Planning Officer: Ms Louisy-Johnson

Planning Application Ref: AL/87/21/PL

Location: Oldlands Farm, Newlands Road, Bognor Regis, PO22 9FJ

Mark Warwick
Tree Officer / Parks and Greenspace Team

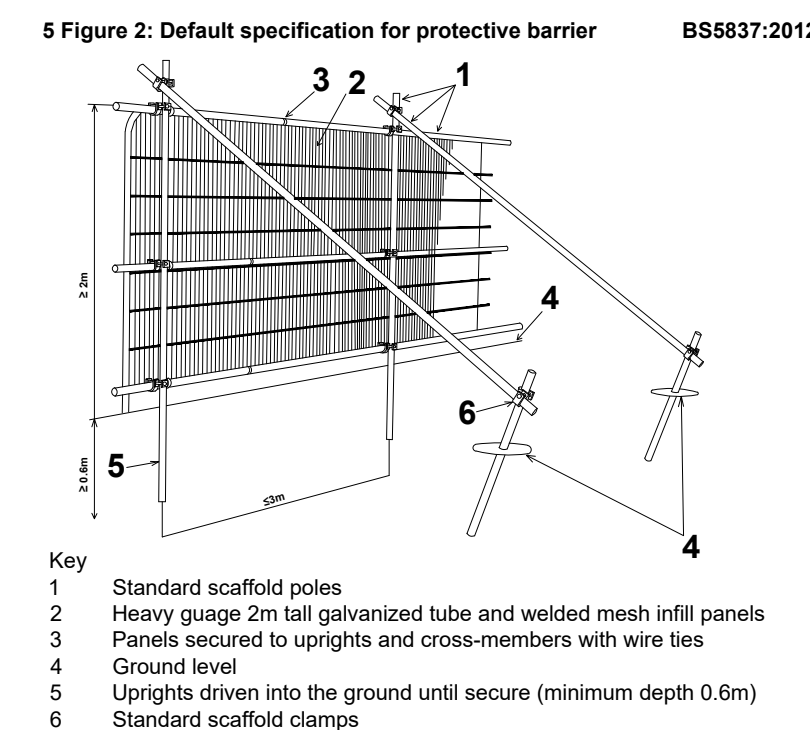
- I have considered Landscape Planting Plan 05-991-701 and Proposed Site Plan 21023-ASA-V0-XX-DR-A-PL03-(S2-P3) REVP3 to gain some understanding of the proposed relationship between retained trees and built form/infrastructure. Although the broadly defined extent of protective fencing is encouraging, we require both a dedicated (stand-alone) Tree Protection Plan showing those trees' crown spread and root protection area in direct relation to proposed layout and associated site-specific Arboricultural Method Statement. Those are essential requirements at detailed application stage.

Figure 2: Illustrative Site Layout Plan

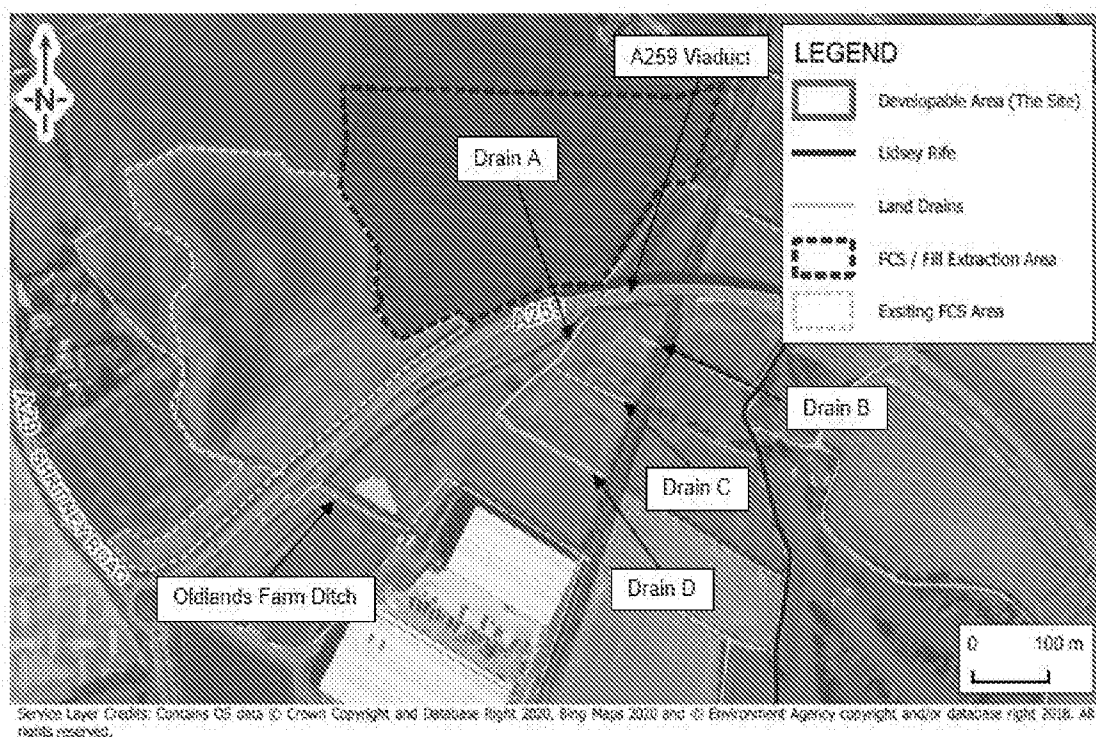
- Infill of existing ditches is proposed across the site (see para. 3.2. of Technical Note from Herrington Consulting Ltd, 27 July 2021, Rev 1). We need to understand whether any such work (or improvements to existing or creation of new watercourses) might occur within or proximity to the RPA (+2m buffer zone) of preserved trees. Confirmation and details to be provided in advance and to our satisfaction. Where there is a significant risk of damage to those trees arising from such operations, then an alternative strategy should be proposed.
